**From:** Anita Gardner [<mailto:Anita.Gardner@arun.gov.uk>]  
**Sent:** 16 July 2014 14:17  
**To:** Derek Bowerman  
**Subject:** AB/72/14/HH and AB/73/14/L - 43 King Street, Arundel

**Our Ref:** AB/72/14/HH

DRG. No.	13151-02 B
SCALE	1:50
DATE	November 2013
DRAWN	SR
CHECKED

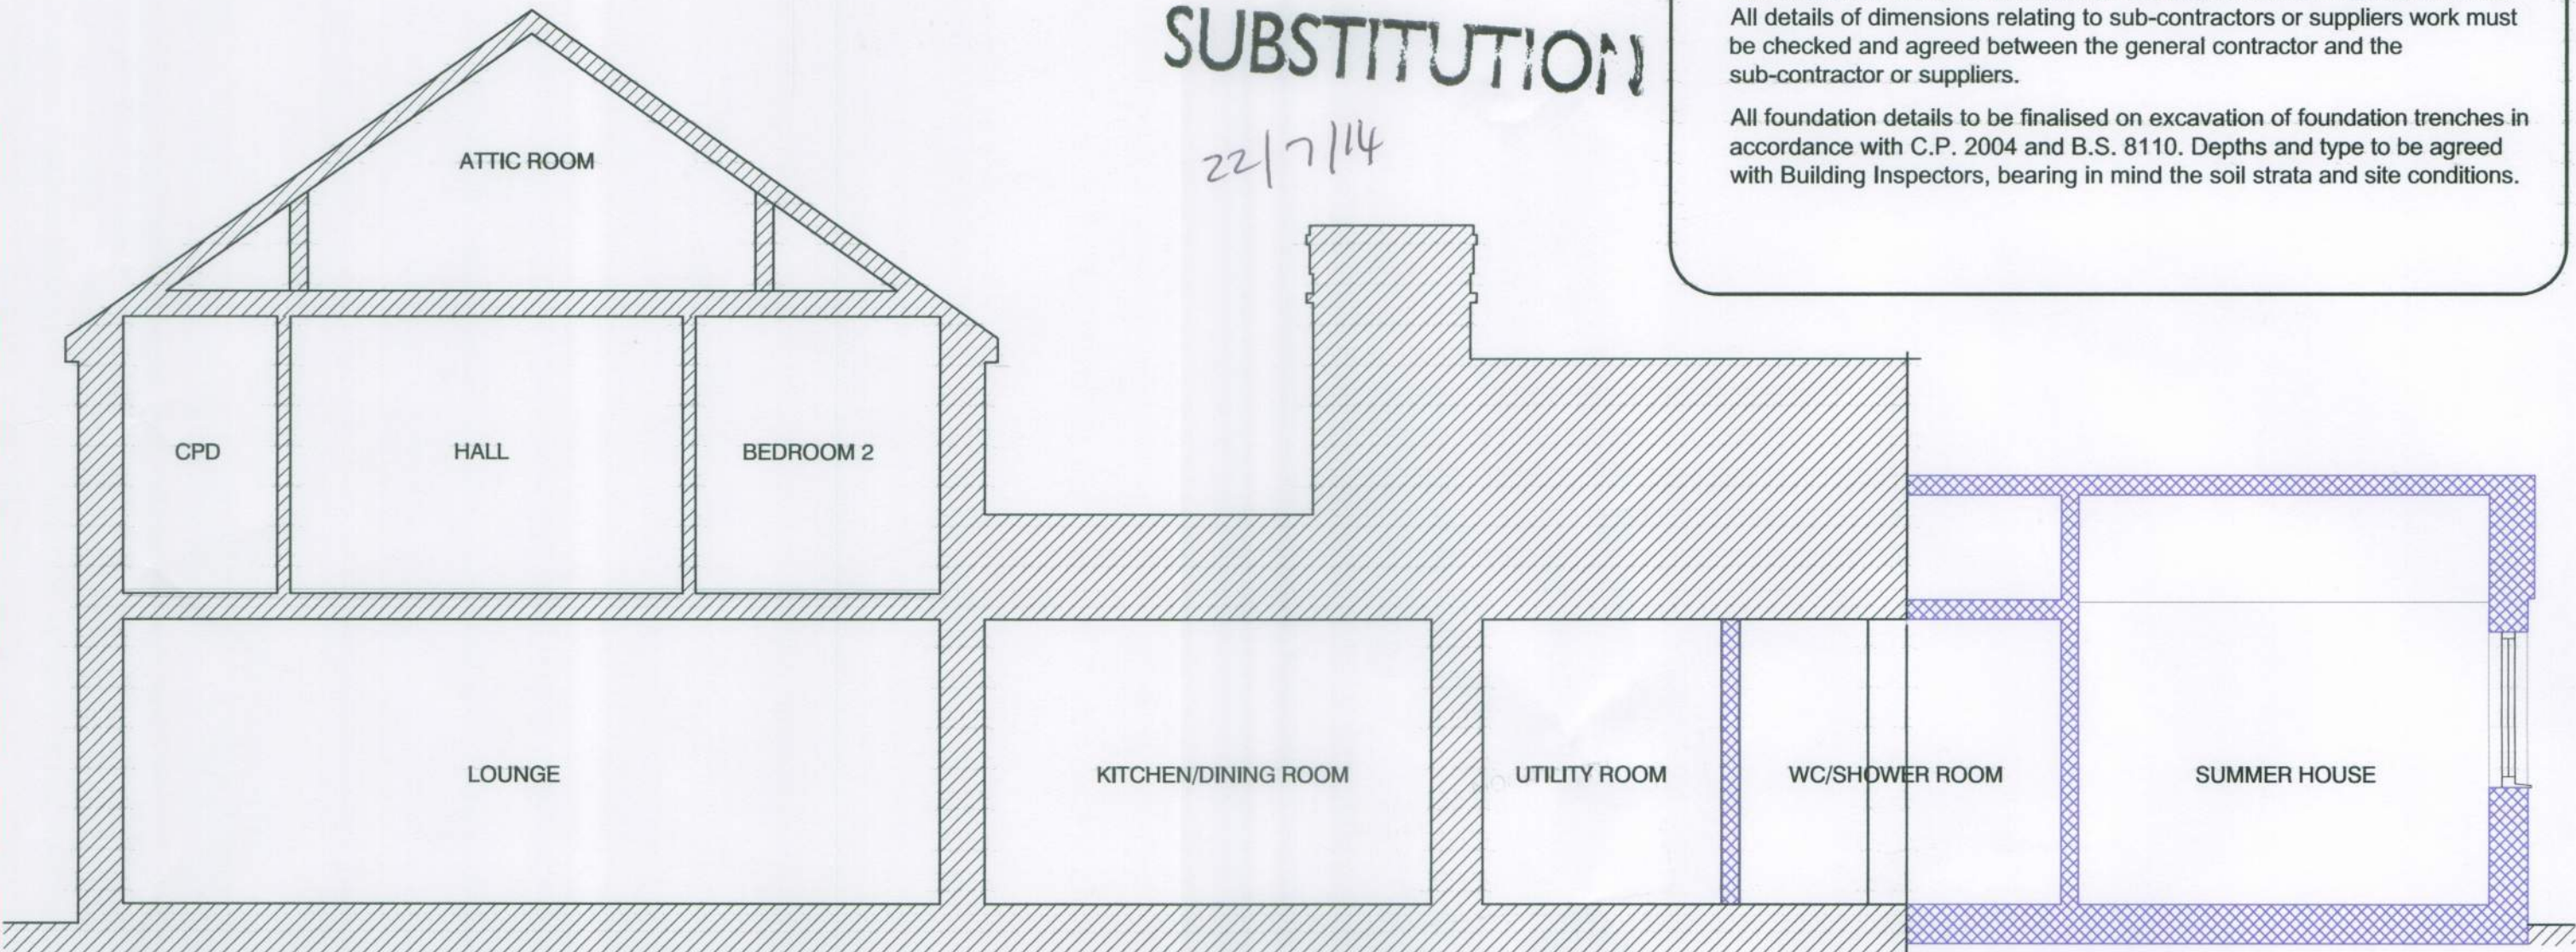
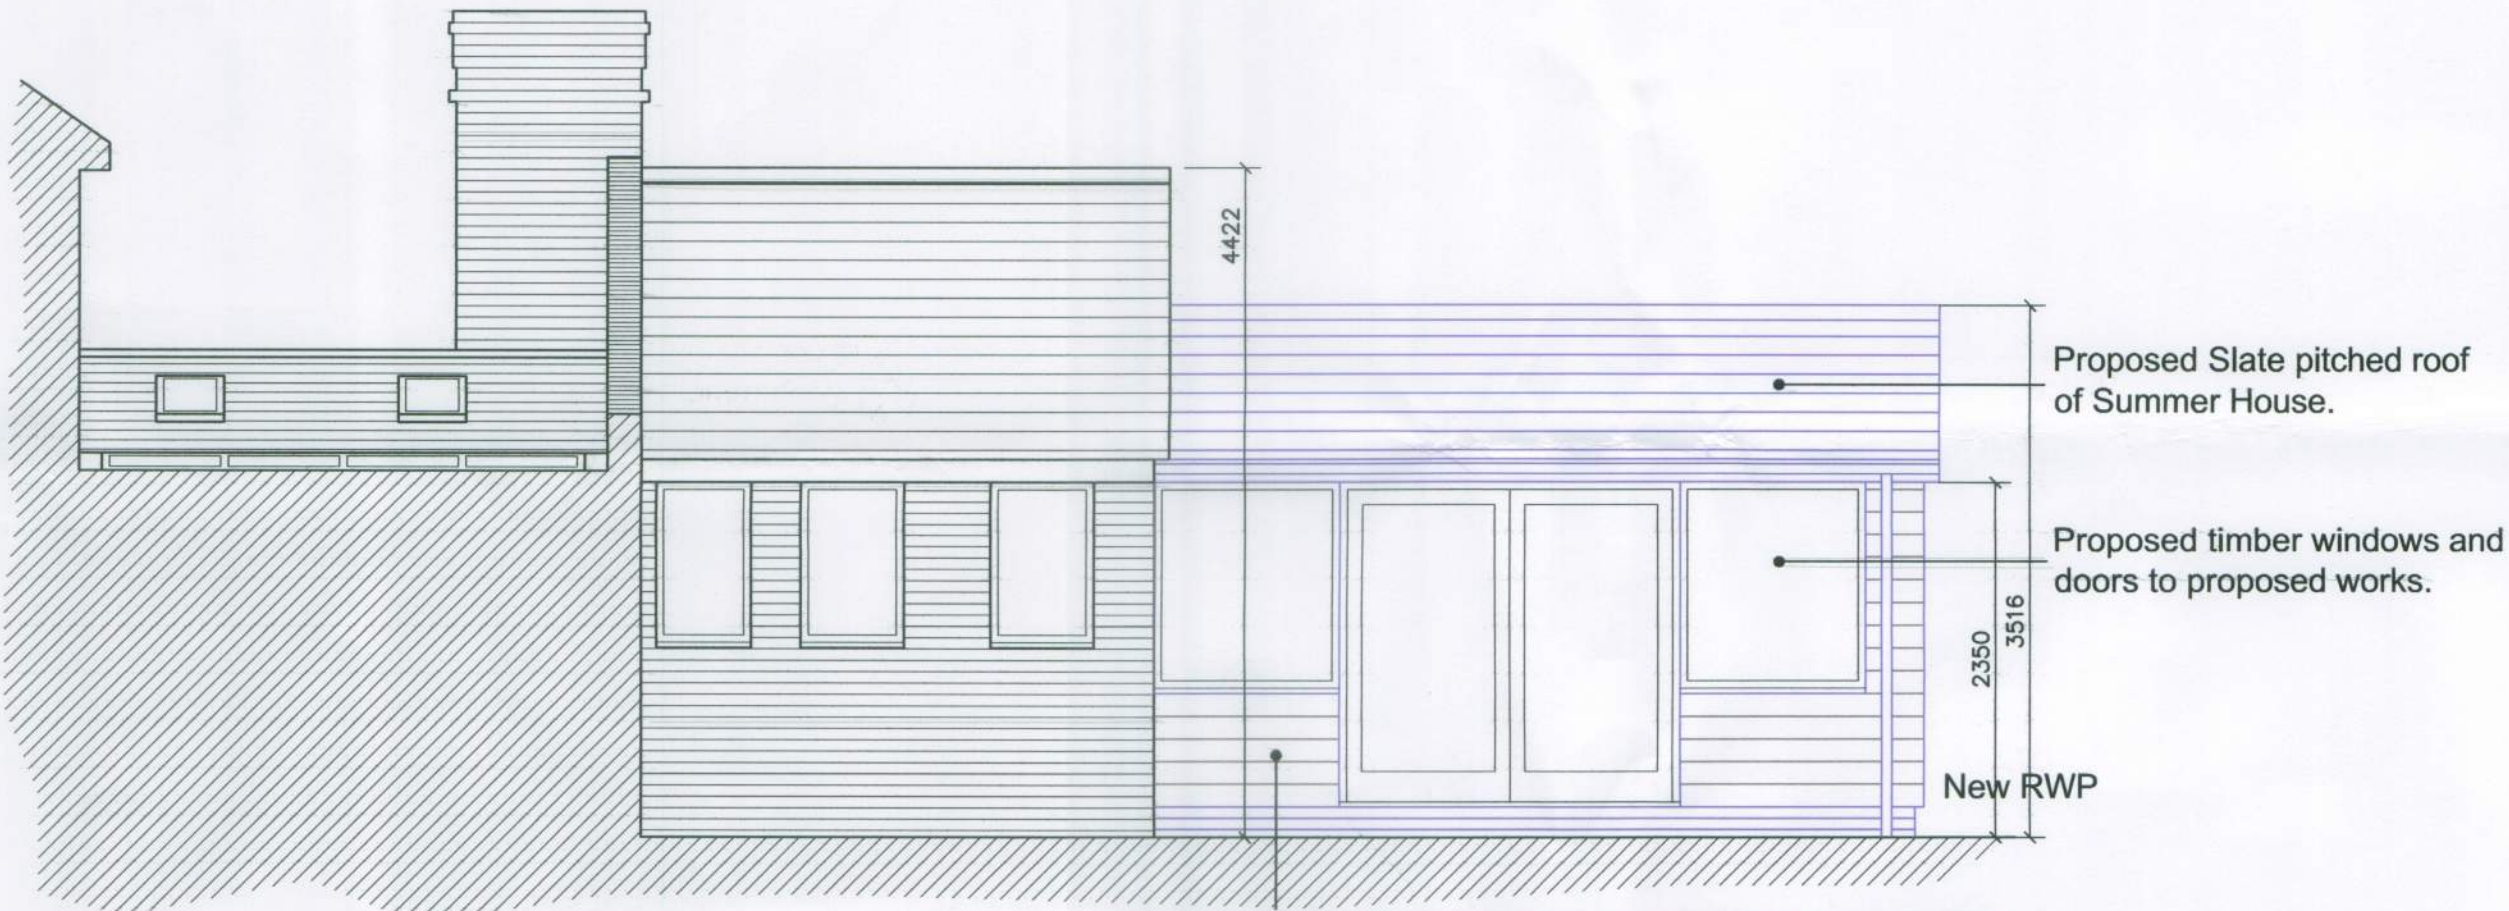
I have visited the above site today and viewed the proposal from the neighbour's garden. The submitted elevations are incorrect. As you can see from the attached photograph the existing roofs to the rear of the existing dwelling are not the same height. The roof of the original outbuilding is also higher than indicated, at least eaves height of the original dwelling or above. Given the inaccuracies of the existing elevation plans it is not easy to accurately determine the height of the proposed roof.

Without prejudice, please provide accurate dimensioned elevation plans for consideration within the next 7 days.
